### **Answer to question 6.17 – Yatehouse Lane Crossing Design**

## **Written Representations – Keuper Gas Storage Ltd**

HOLFORD BRINEFIELD - KGSP - DEVELOPMENT AT WELLHEAD H502

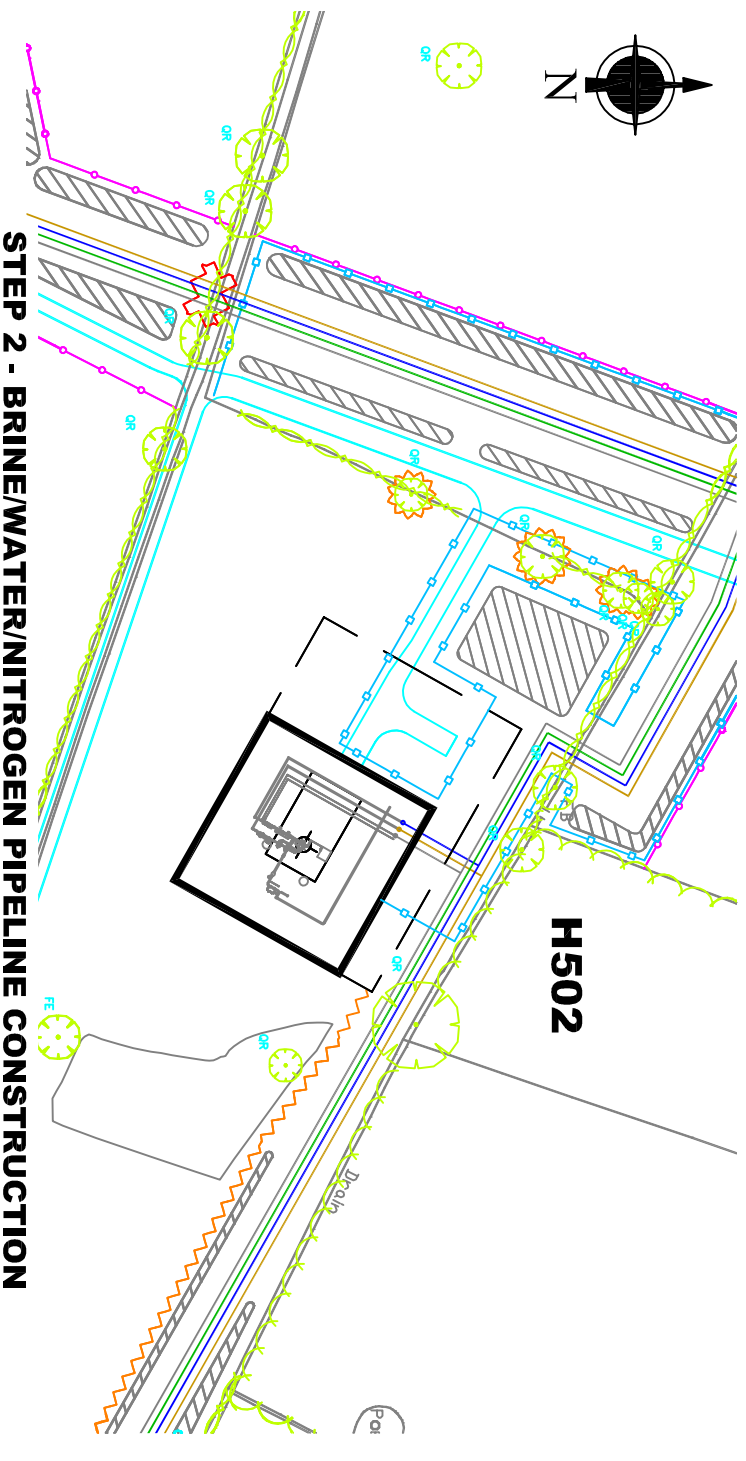
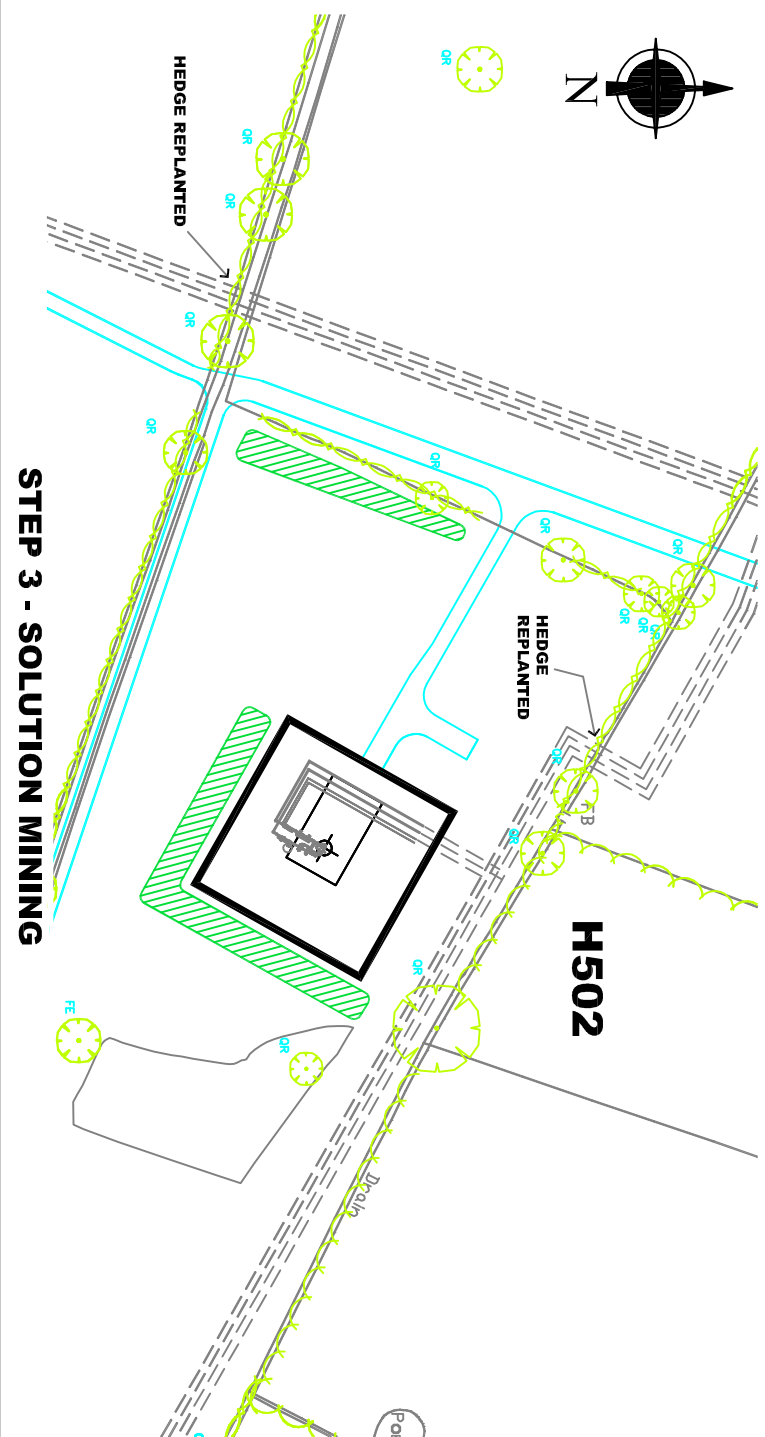
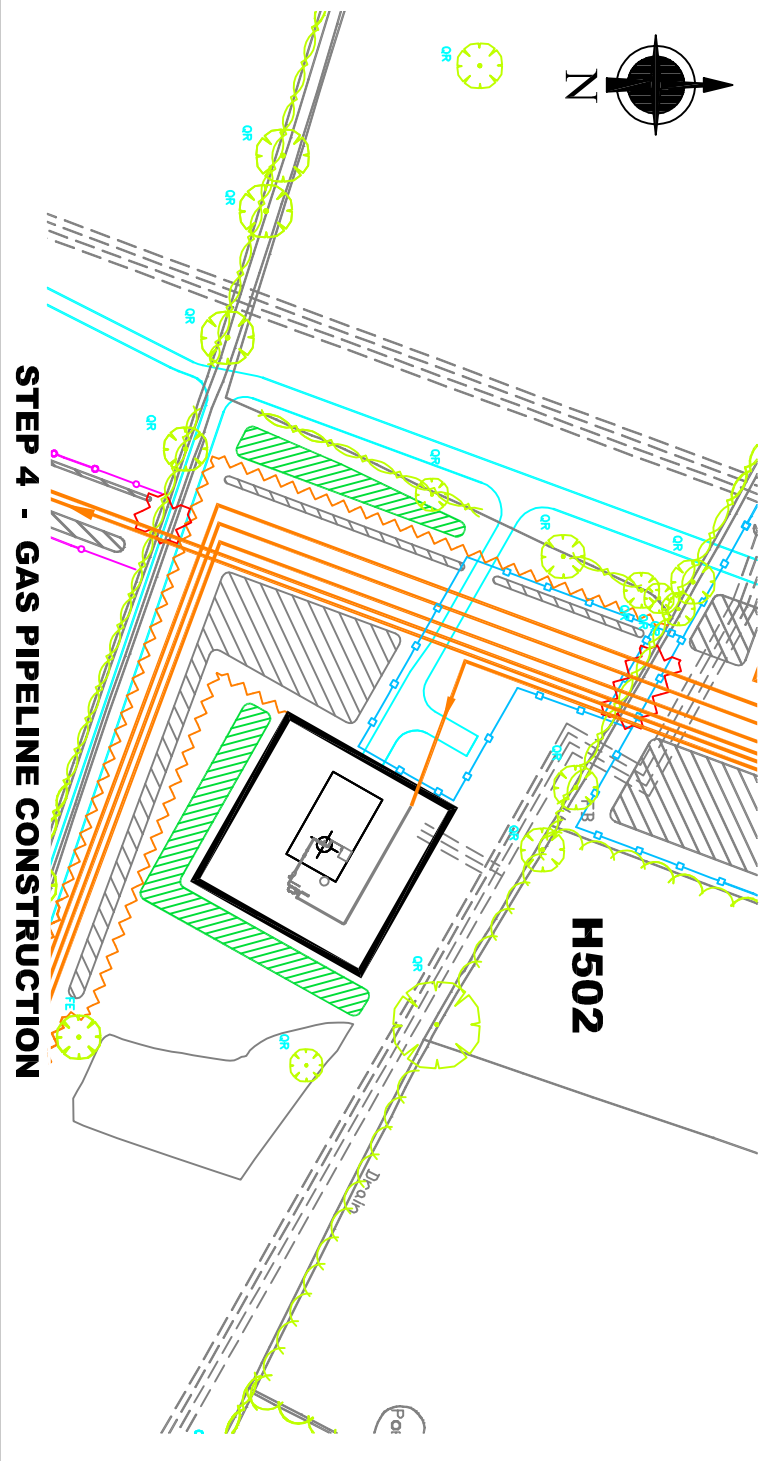
The design incorporates the removal of hedging to increase the visibility splays however, the height of the ground has not been considered and is unlikely to increase visibility splays as much as stated. The design also does not take in to account the increase commercial activity during and post construction and how they integrate with the users of the track from Brown Hayes Farm and the adjoining property. The residential use will increase in the near future as planning permissions have been obtained to turn the site of 3 houses into a site of 6 houses and obviously the increase of traffic that comes with the additional dwellings.

We believe that it is completely unreasonable to request that the occupiers of the 6 dwellings have got to share this access with industrial/commercial vehicles in particular, during the construction period and also post construction as this will only increase the potential risk of a accident.

We also consider there to be several other safer crossing points along Yatehouse Lane that would not require the removal of such hedgerow or the increase risk to public safety.
